## Sheringham and Dudgeon (Windfarm) Extension Projects

### Perenco UK Limited Summary of Oral Submission at ISH6

**Figure 3.1 Proximity of Dudgeon Wind Farm Turbines to the Waveney Platform**

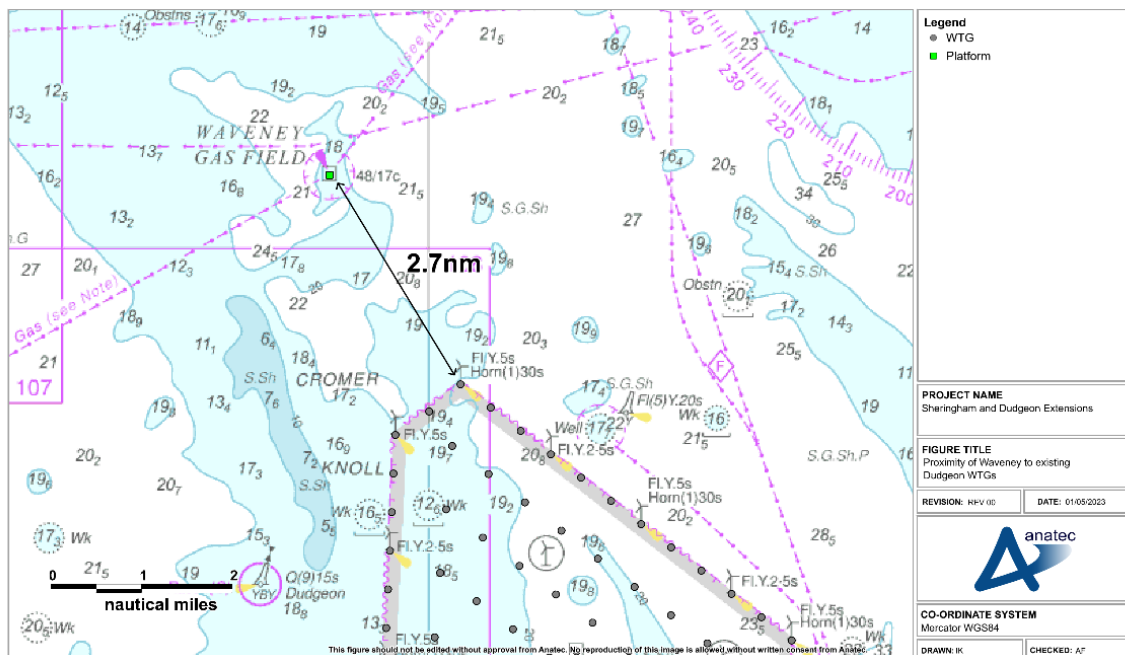
- Wind turbines located within 7nm downwind of Waveney would limit Airborne Radar Approaches;
- Wind turbines located within 3nm of Waveney in any direction would, under anticipated new rules agreed by all of the North Sea Helicopter operators and the CAA, restrict flights to daylight and when visibility exceeds 5km and the cloudbase is at least 700';
- Wind turbines located within 2.33nm upwind of Waveney would require a change from standard procedures should an engine fail during take-off;
- Wind turbines located within 1.42nm upwind of Waveney would preclude a take-off in the event of one engine being inoperable (OEI);

- Wind turbines located within 1.34nm downwind of Waveney or within 1.01nm perpendicular to the approach direction would prevent helicopter access to Waveney.
